HAY CREEK VALLEY

PRELIMINARY PLAN

HAY CREEK VALLEY SUBDIVISION
 PRELIMINARY PLAN

EL PASO COUNTY, CO
 APRIL 2023

LOT TYPICAL
NTS

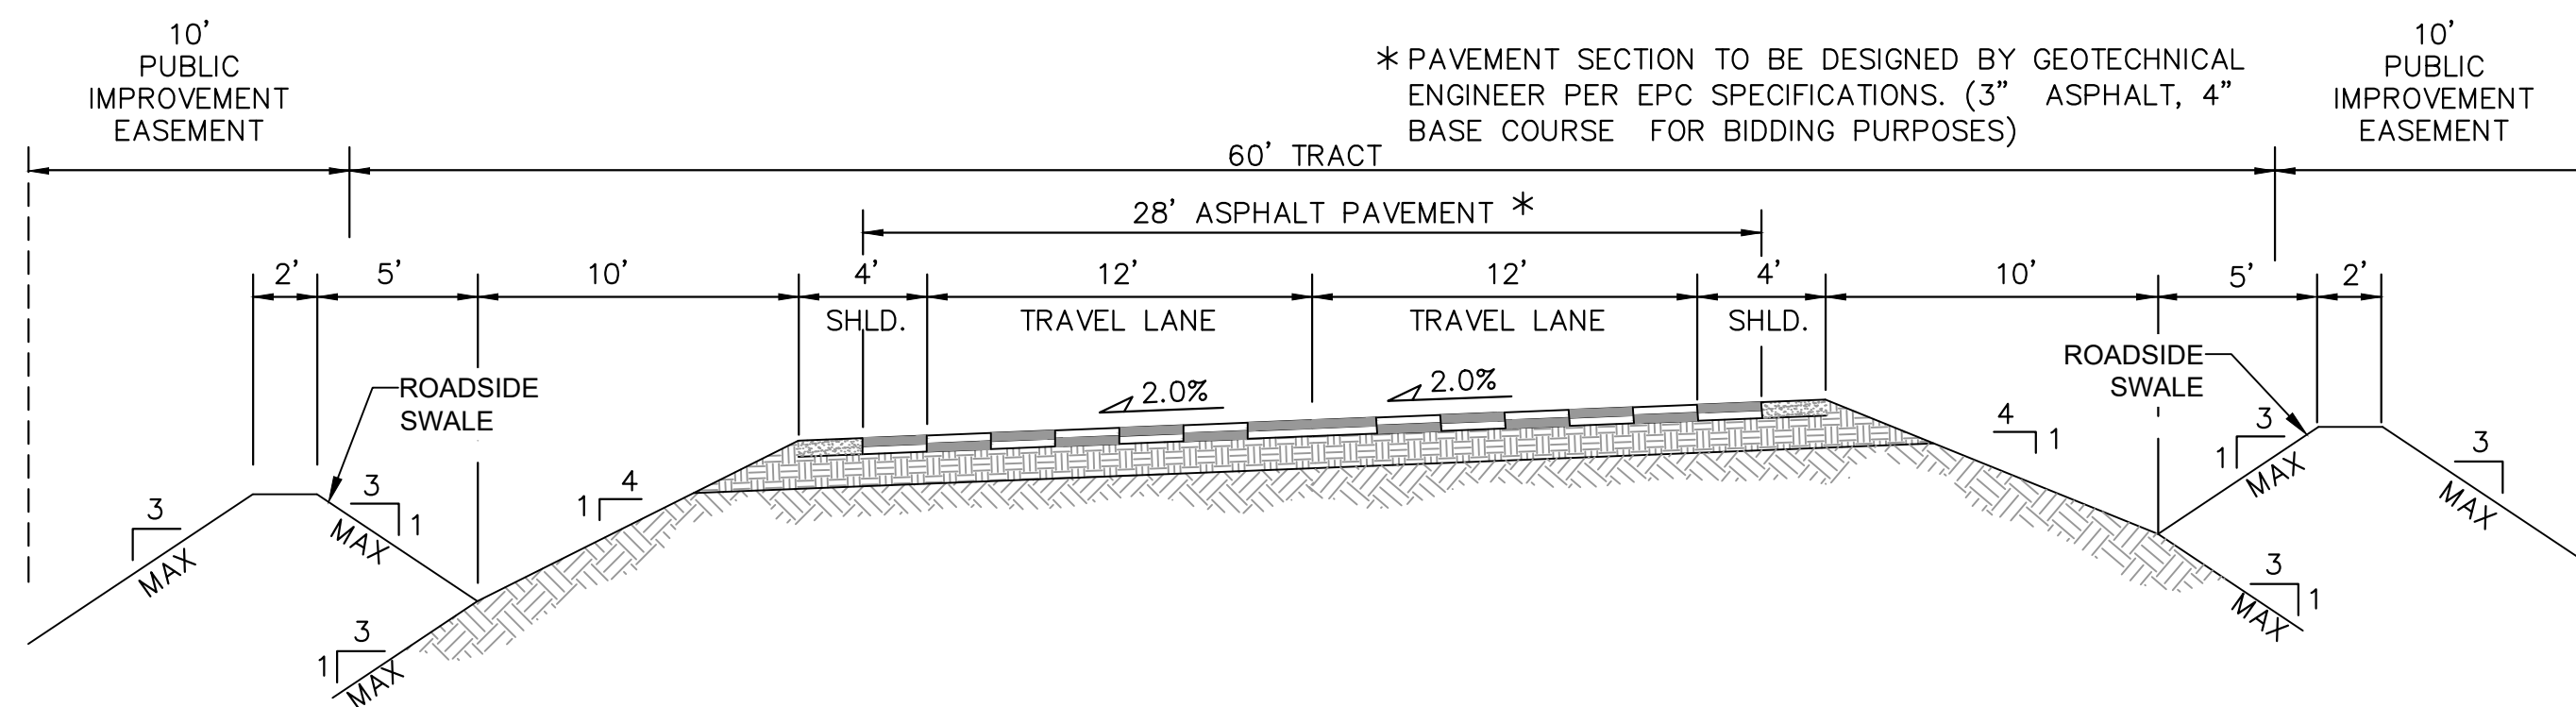
Revise to Tract for private road since no ROW

Please add design and posted speed.

Update the cross section to match the drainage plan. The proposed drainage map shows the entire road is superelevated and sloping to the north with no crown at centerline.

If that is correct then a deviation request from ECM 2.3.3.D.2 is required. "superelevation is not permitted on roadways with design speeds less than 50 mph."

GN02

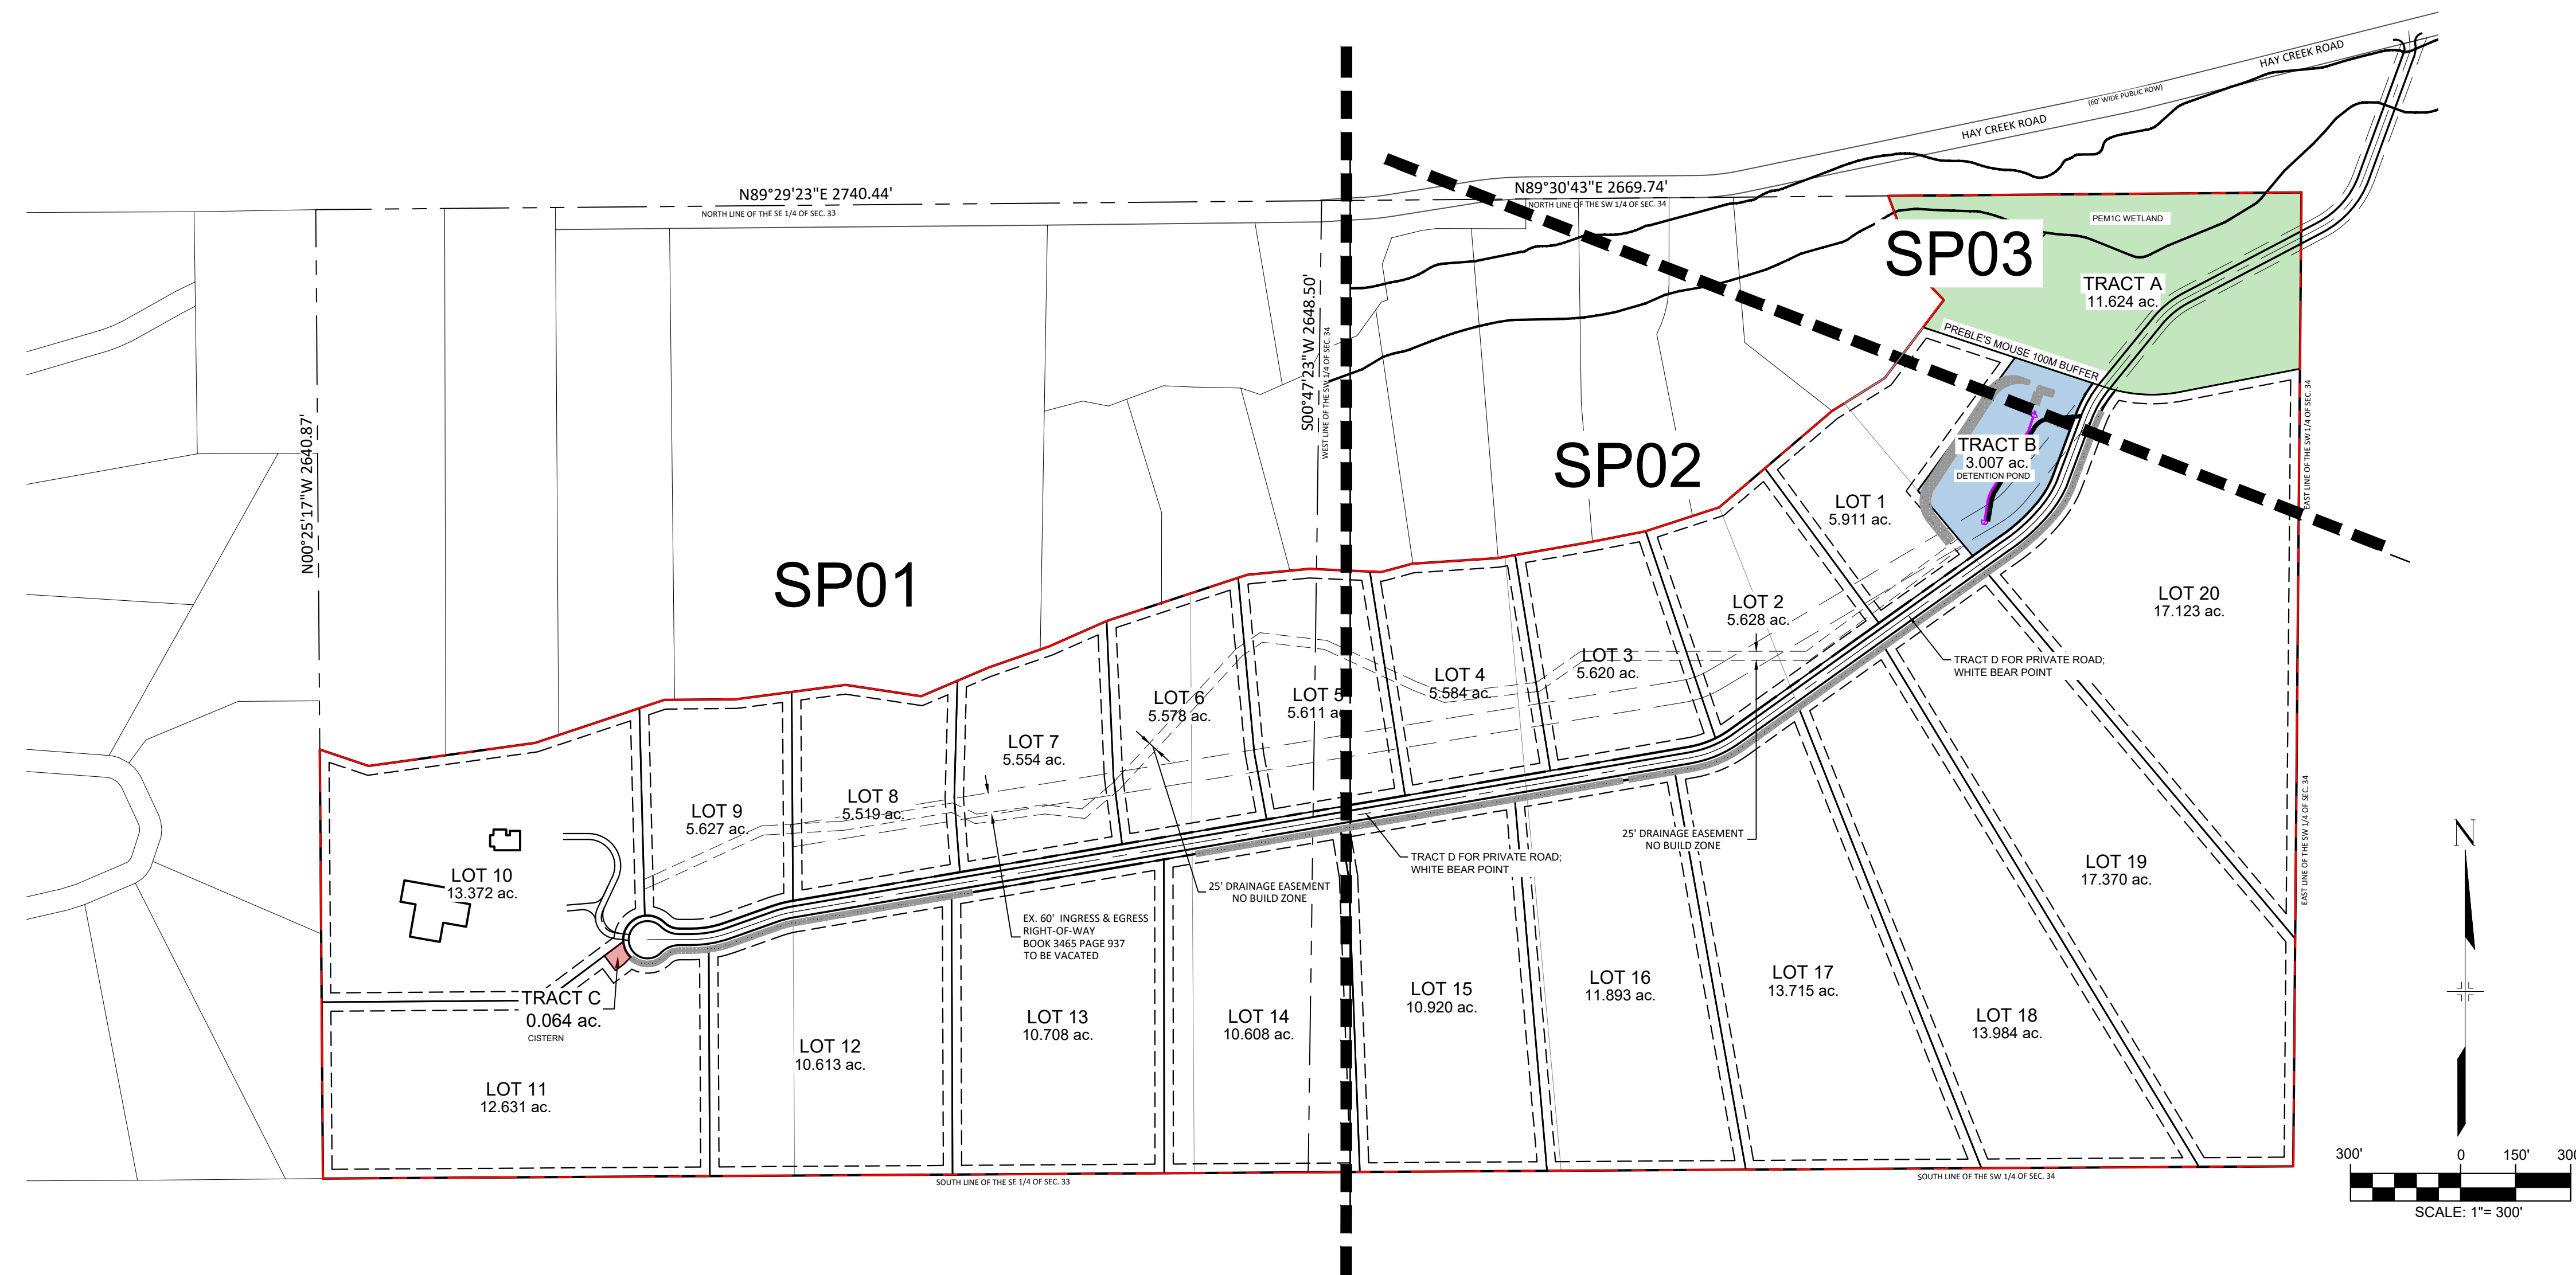
Identify hazards that are located on each individual Lot
 Floodplain
 Bedrock
 Drainage
 Building Restriction
